Water Eaton Development: PR6a: Planning Application - 23/01233/OUT

This response is prepared by CycloX, the cycle campaign group for Oxford. We campaign to put cycling at the heart of Oxford's future. Our purpose is to get more people cycling, more often, and more safely in and around Oxford. We collaborate with key decision makers to put cycling on the public agenda; partner with active travel and low-carbon groups; and engage with the local community to inform, encourage, and support change.

Connectivity to Oxford Road A4165 and Cutteslowe Roundabout ITB16565-SK-074 Oxford Road Cycle improvements (South)

DRAWN	CHECKED	APPROVED
PH	JDW	JDW
PROJECT No:	SCALE @ A1:	DATE:
ITB16565	1:500	13.01.23
DRAWING No:	ITB16565 - SK - 067	
		REV: H

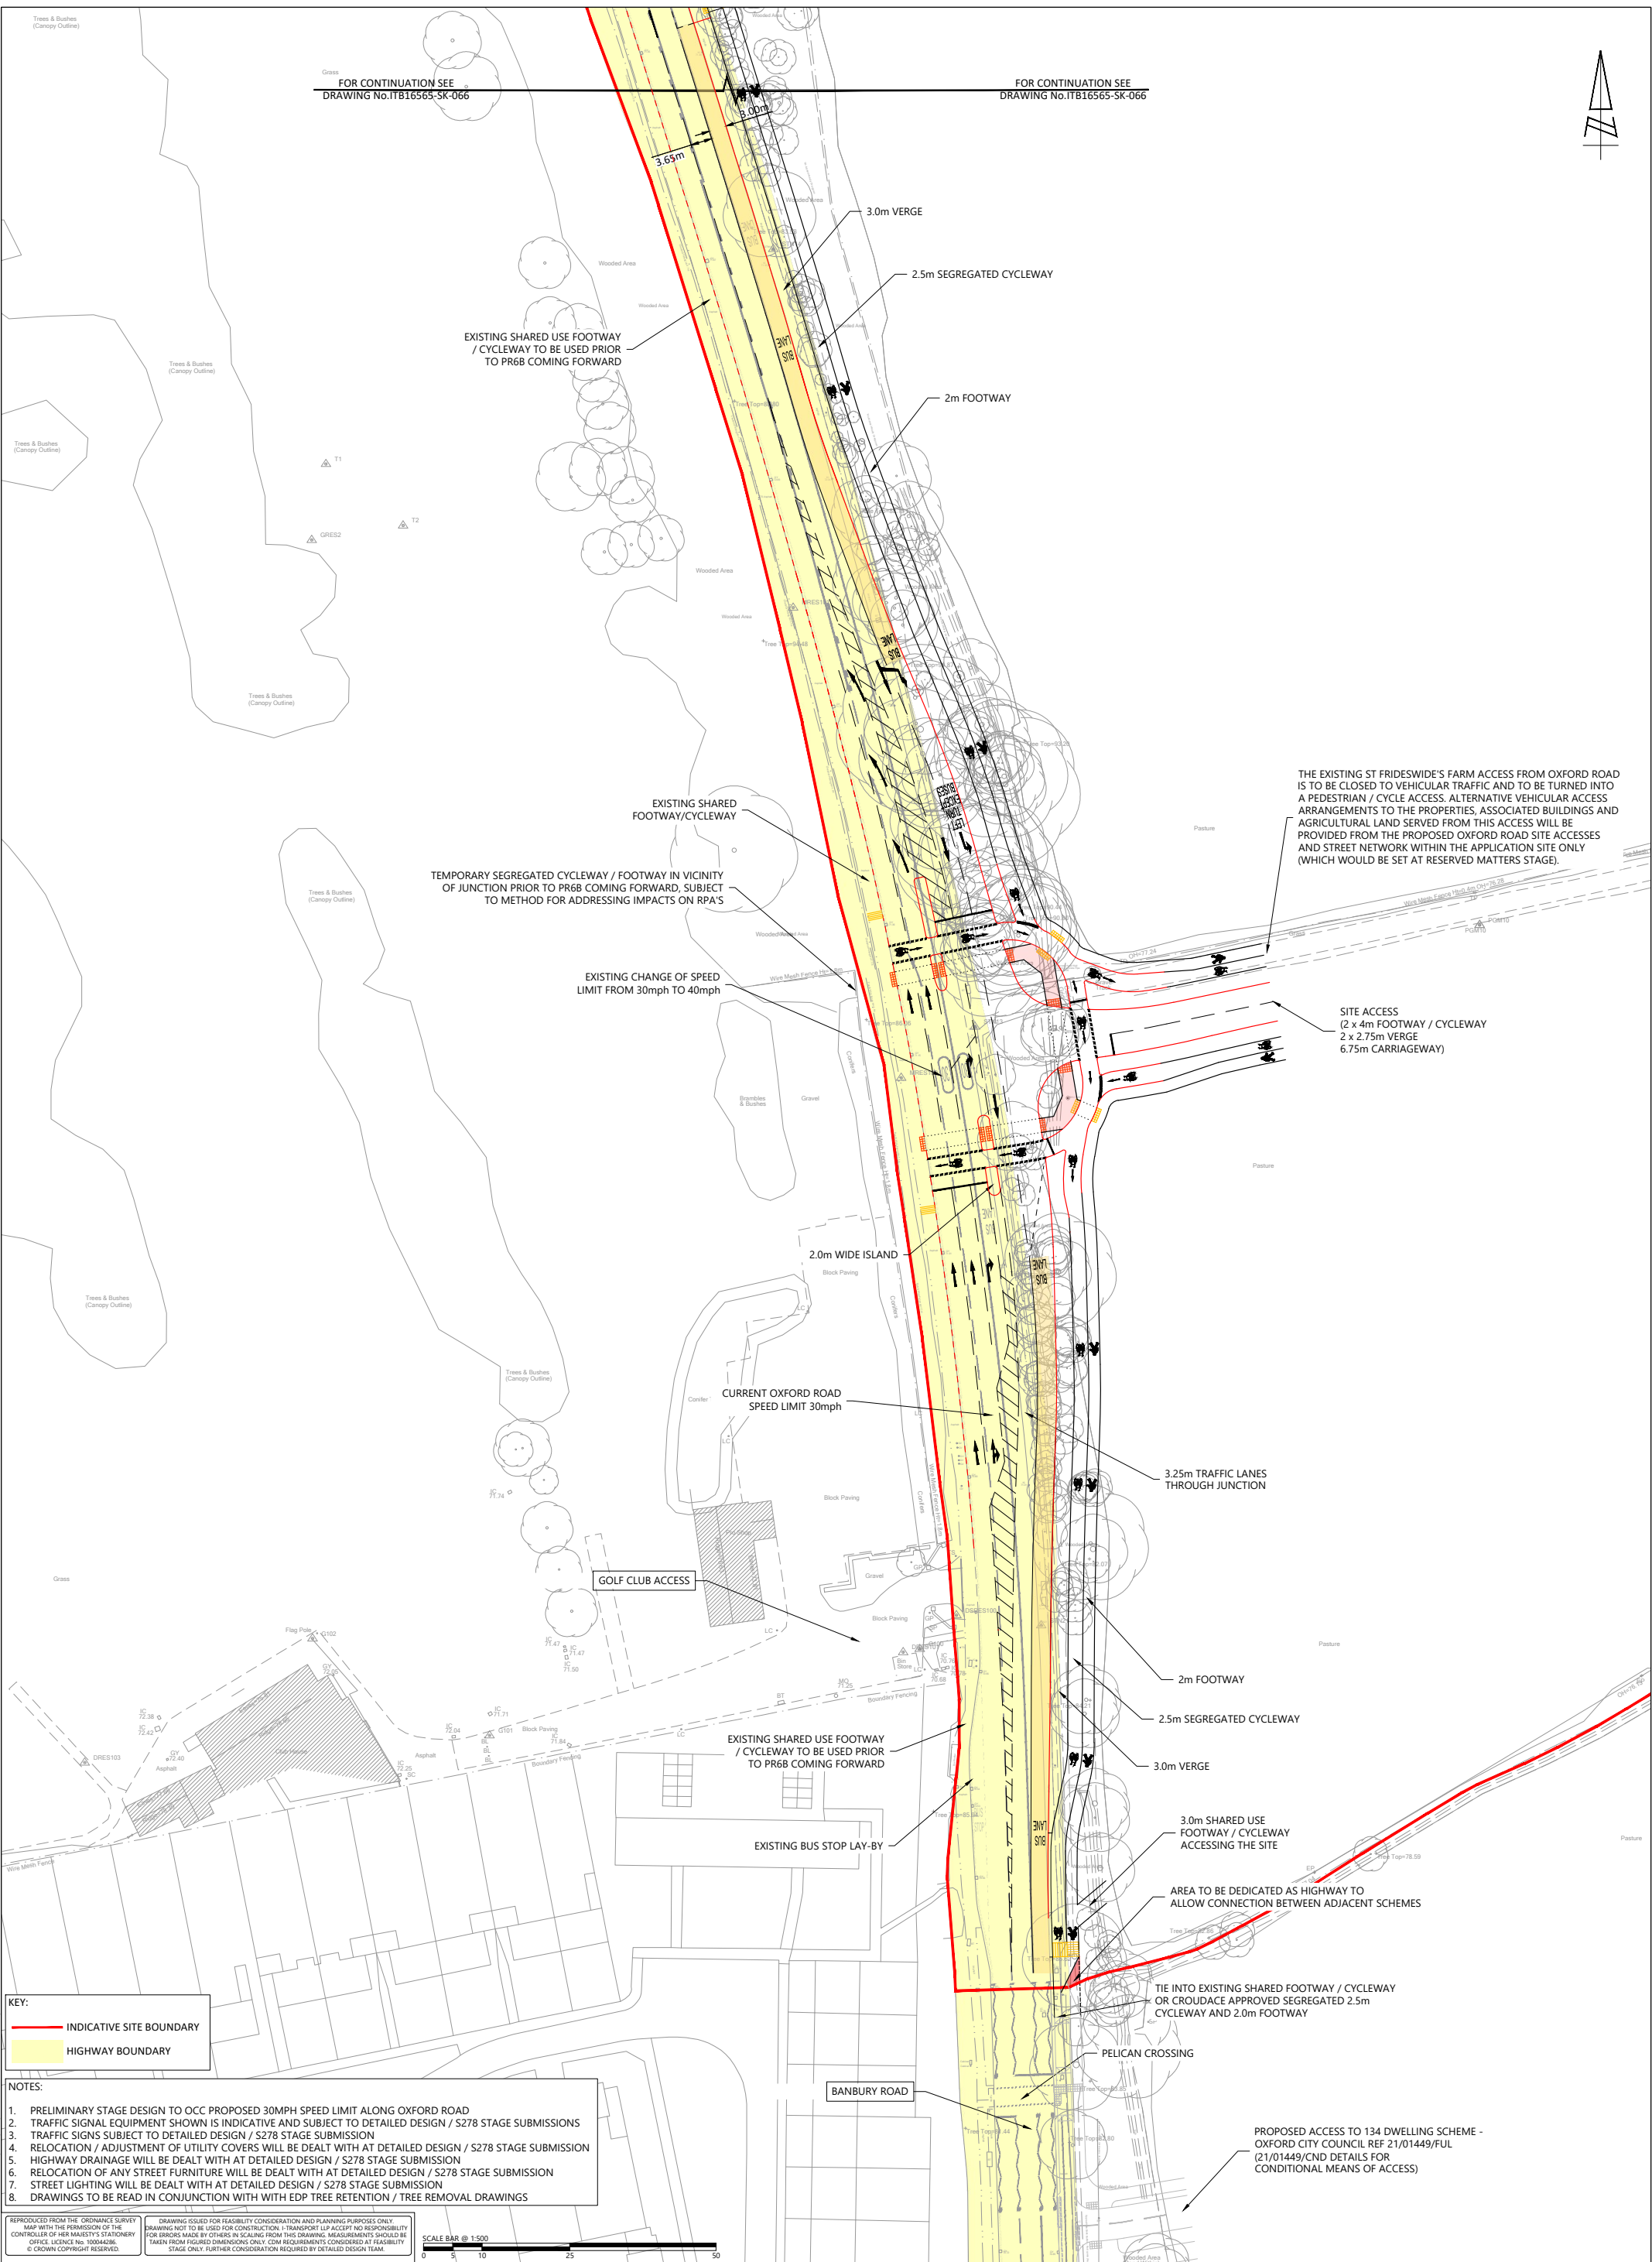
We believe that cycle path and pedestrian crossings of side roads should be *no set back design priority* as per LTN 1/20 Figure 10.13. The cycle paths constitute a key commuter route to and from Oxford and deviations and delays should be designed out.

The side road entries of Five Mile Drive and Harbord Road should also be *no setback design priority* as per LTN 1/20 Fig 10.13.

The crossing of the access to PR 6b should be designed in the same way, i.e. *no set back design priority* – not as shown on the application drawing above.

We think that all crossings of Oxford Road should have parallel, single stage crossings on raised tables with zero delay for pedestrian/cycle green signal. All as per 10.4.21 of LTN 1/20.

The proposed relocation of the existing Toucan crossing is problematic. It is unclear to where it will be relocated. It should be close to the west side bus stop in order to allow direct access to the ramp to the train station for bus passengers coming from the south. This crossing is currently well used.
